Reference No: 2021/62/93700/W

Site Address: 92-94, Halifax Old Road, Birkby, Huddersfield, HD2 2RP

Description: Erection of single and two storey rear and single storey side extensions with external alterations, erection of canopy over outdoor gym and play area [within a Conservation Area]

Officer Report.

CLIENT	Mr M Saeed		
ADDRESS	92-94 Halifax Old Road Huddersfield, HD2 2RP		
PROJECT	Two Storey Side and Single Storey Rear		
DRAWING	Proposed Layout and Elevations		
DRAWN	UH	DATE	AUG 21
		SCALE	1.50@A1
DWG No.	2132/03B		
STATUS	PLANNING

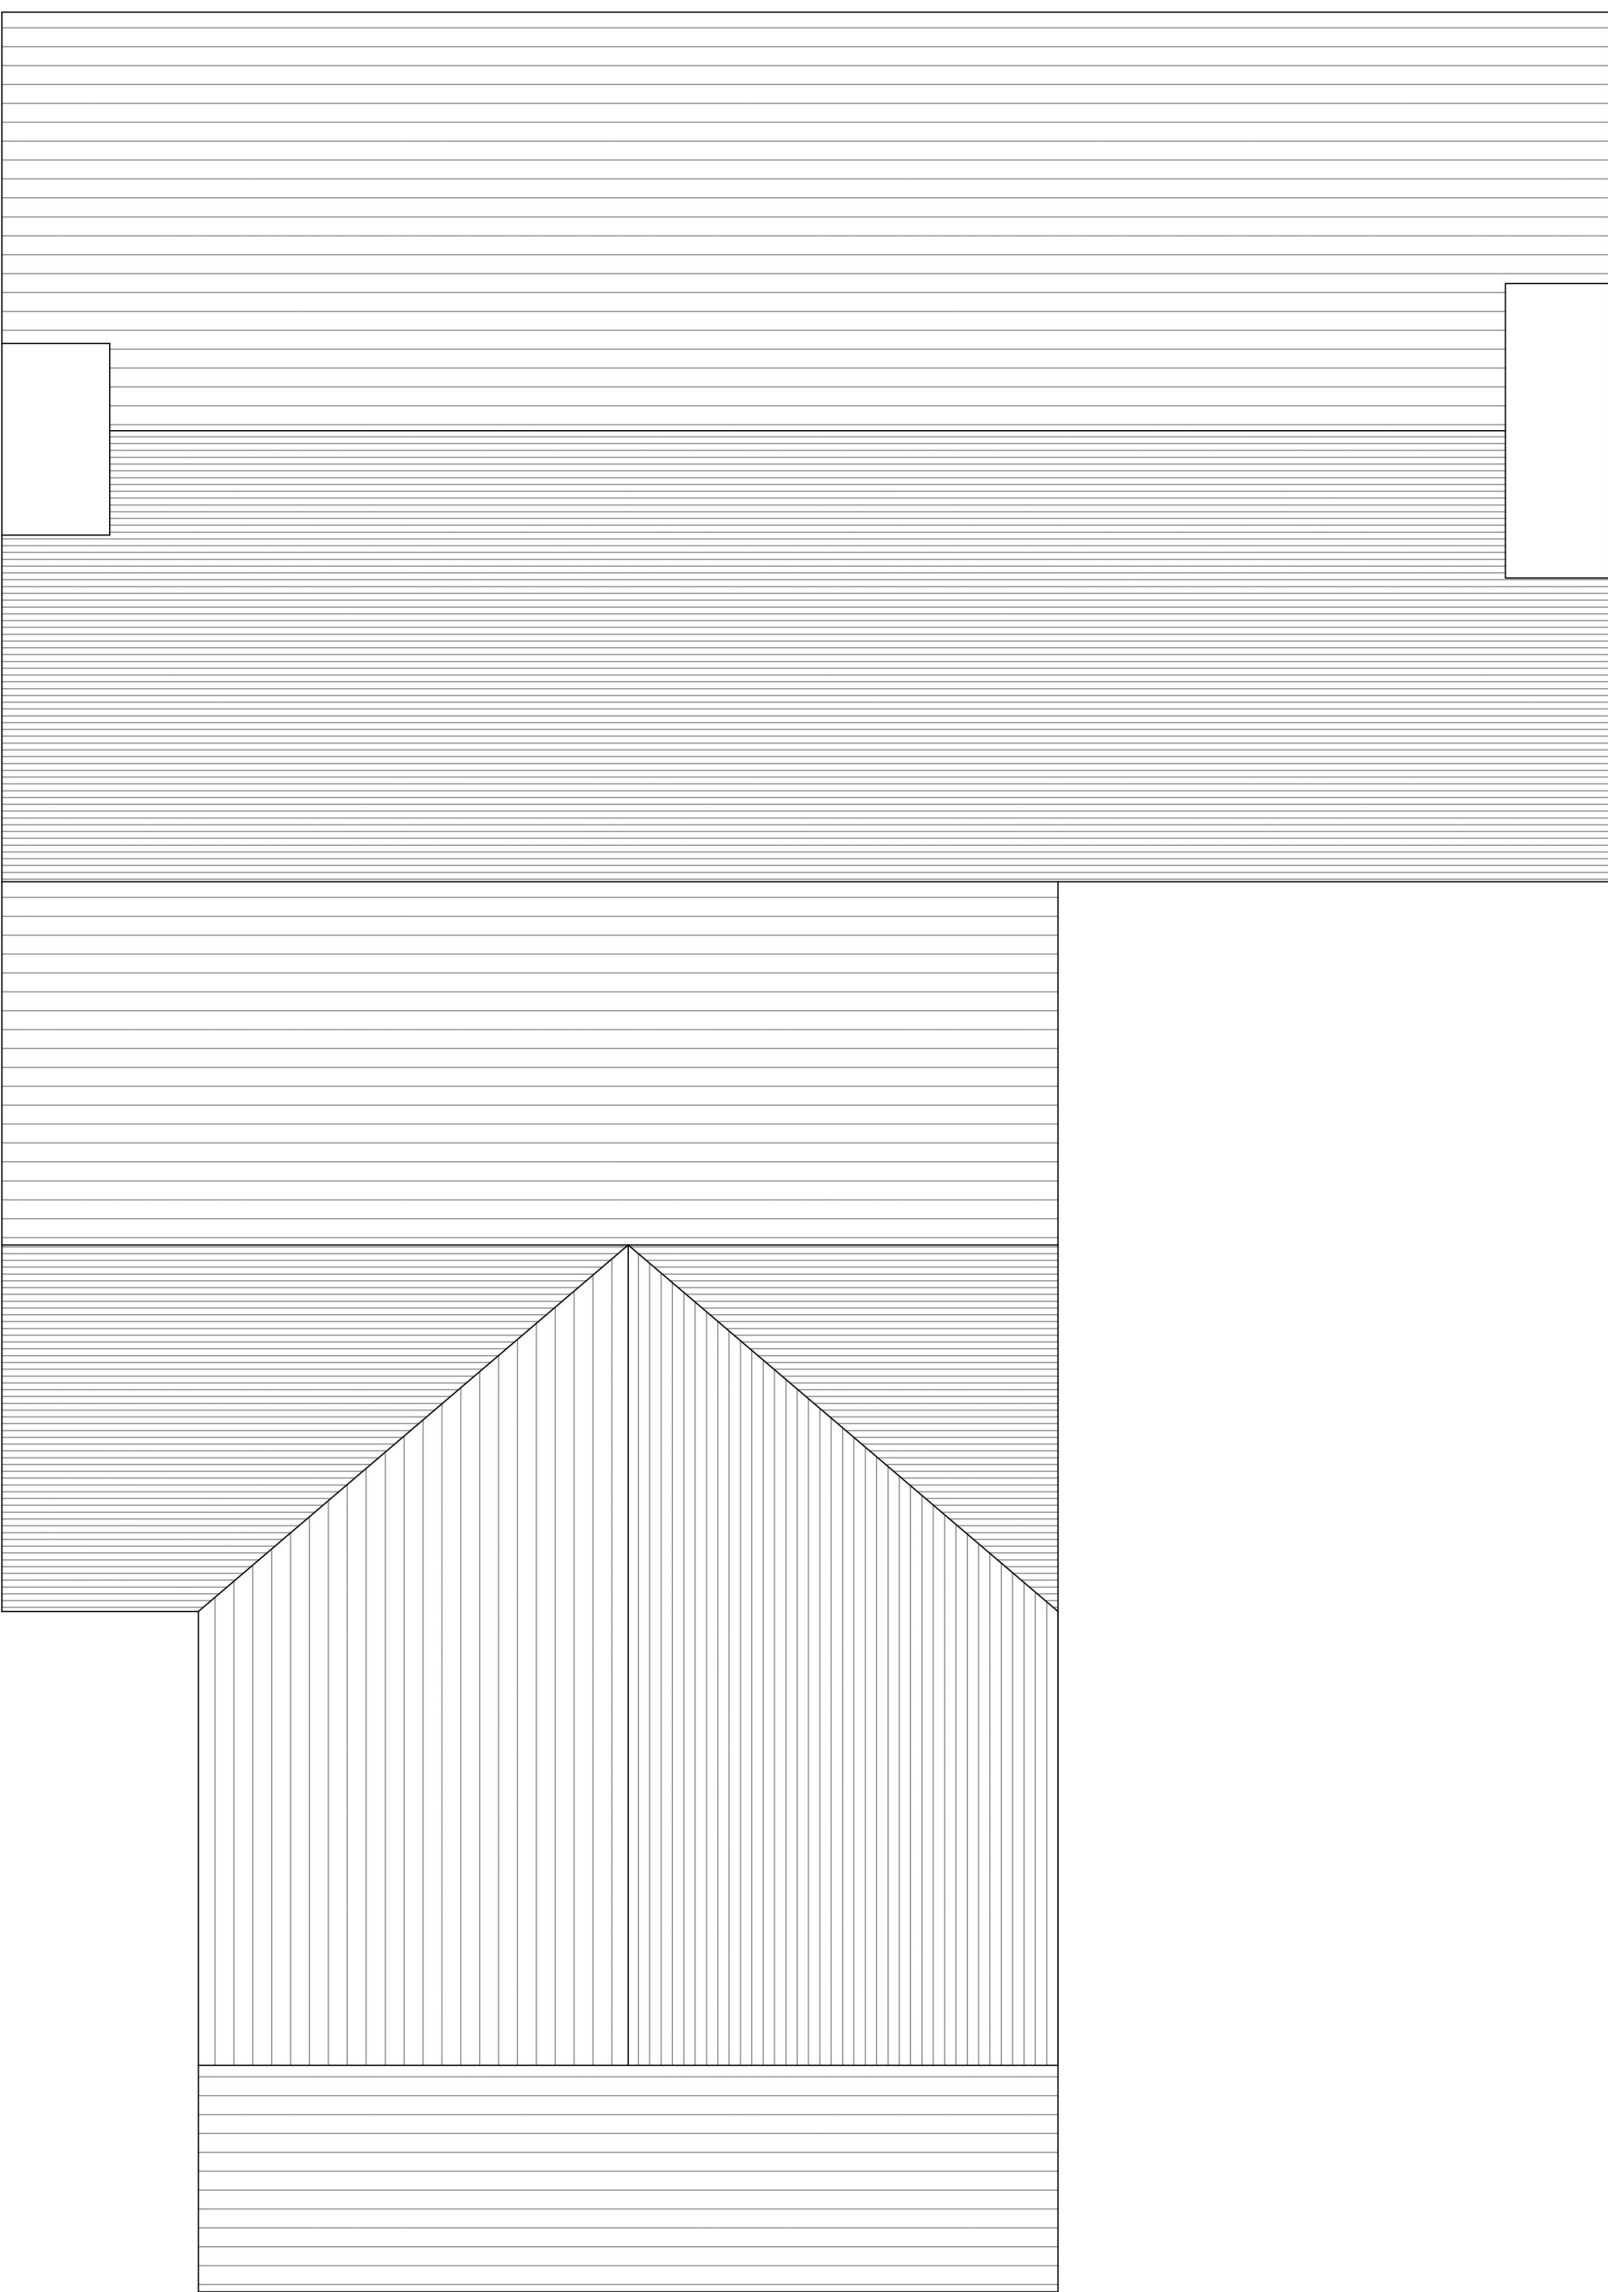
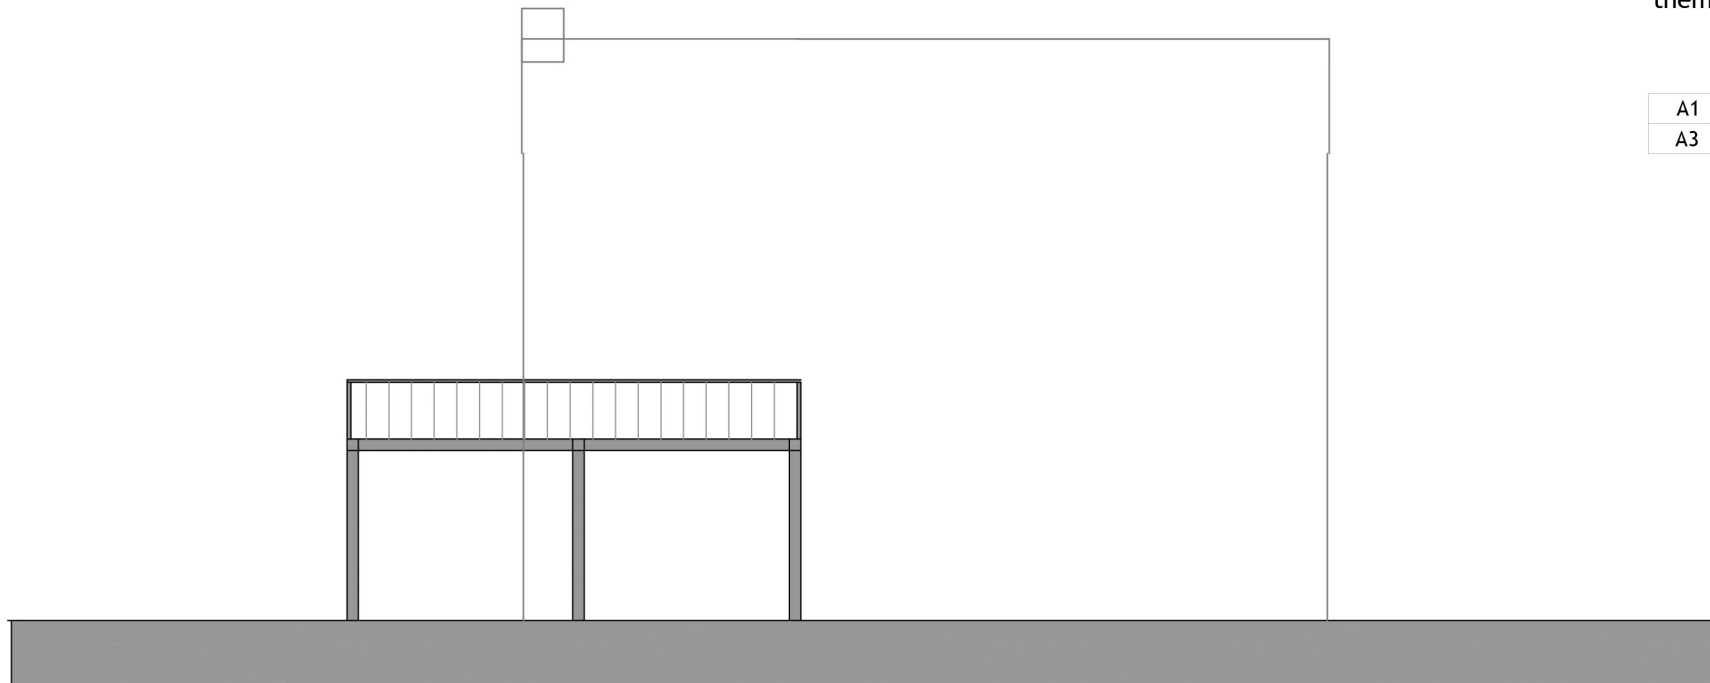
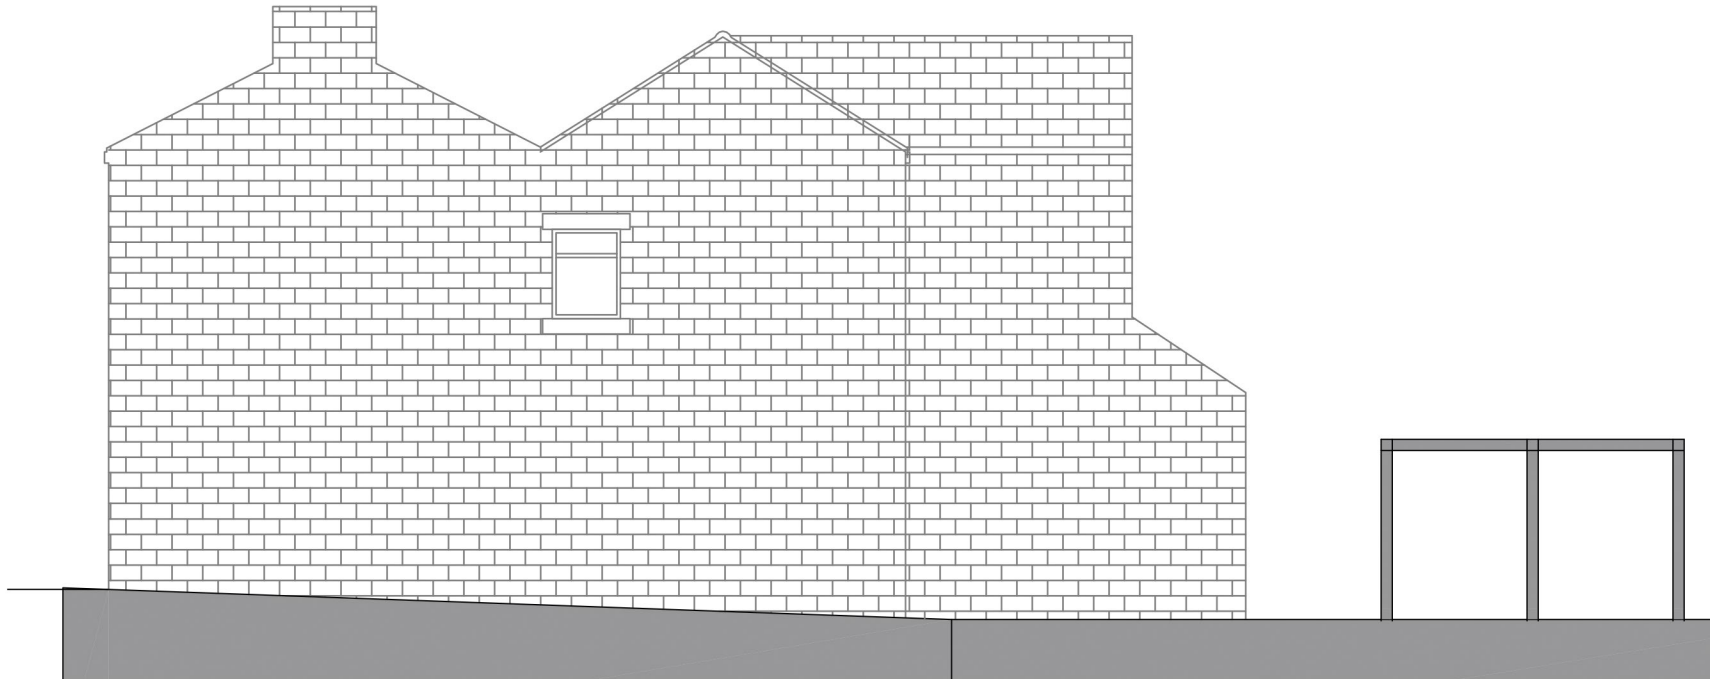
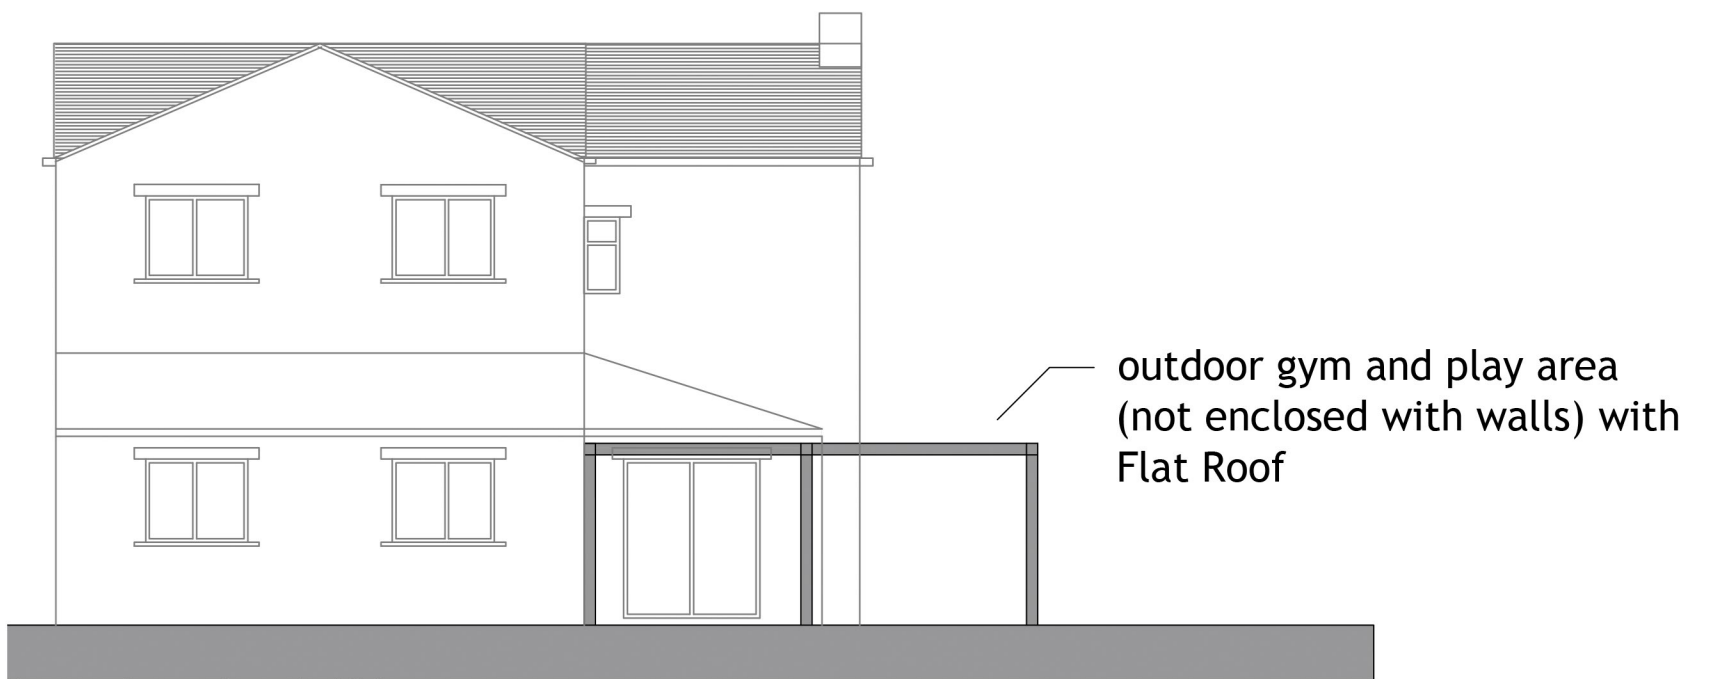
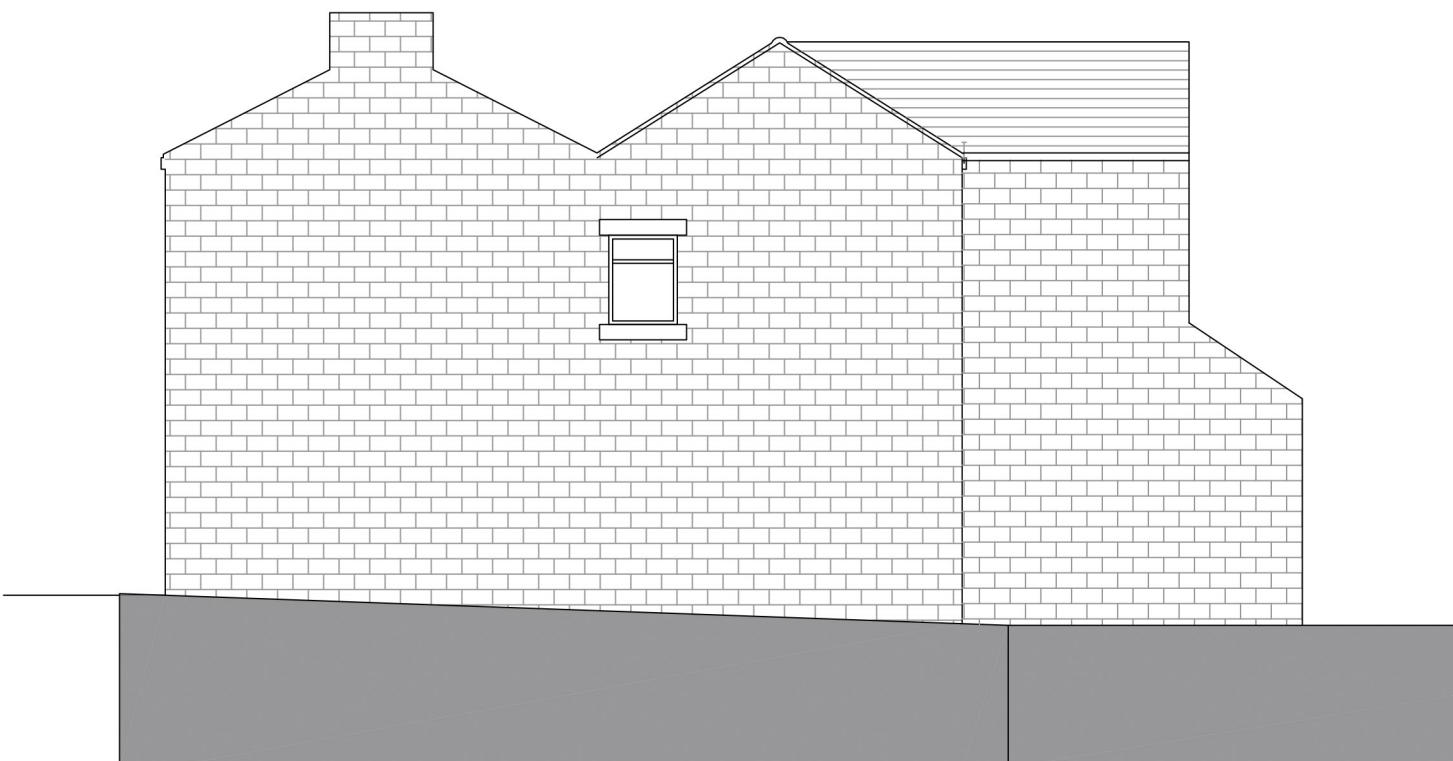
Following this, the case officer once again sought amendments to the proposed scheme, in this instance regarding the canopy. The canopy as originally applied for and which has been previously constructed at the property was accessible with balustrade meaning it is used as a balcony / raised terraced area. Amendments were sought to make this structure serve as a canopy only, with an inaccessible flat roof above. Therefore, the overall determination of this application is based on the latest plans as submitted on 10th December 2021.

The proposed canopy will improve upon current residential amenities, removing the potential for accessing the roof as extra amenity space and instead having only an inaccessible flat roof. In turn, this will diminish impacts of overlooking or to impediment of neighbouring privacy. In addition, given the simple and open form of the proposed canopy, it poses no significant impacts of overshadowing or been overbearing.

4. Within three months of the date of this permission the railings upon the roof, and means of access to the roof, of the canopy annotated 'outdoor gym and play area with flat roof' upon submitted drawing 2132/03RevB shall be removed and the roof shall not be used as a balcony or terrace at any time throughout the lifetime of the development.
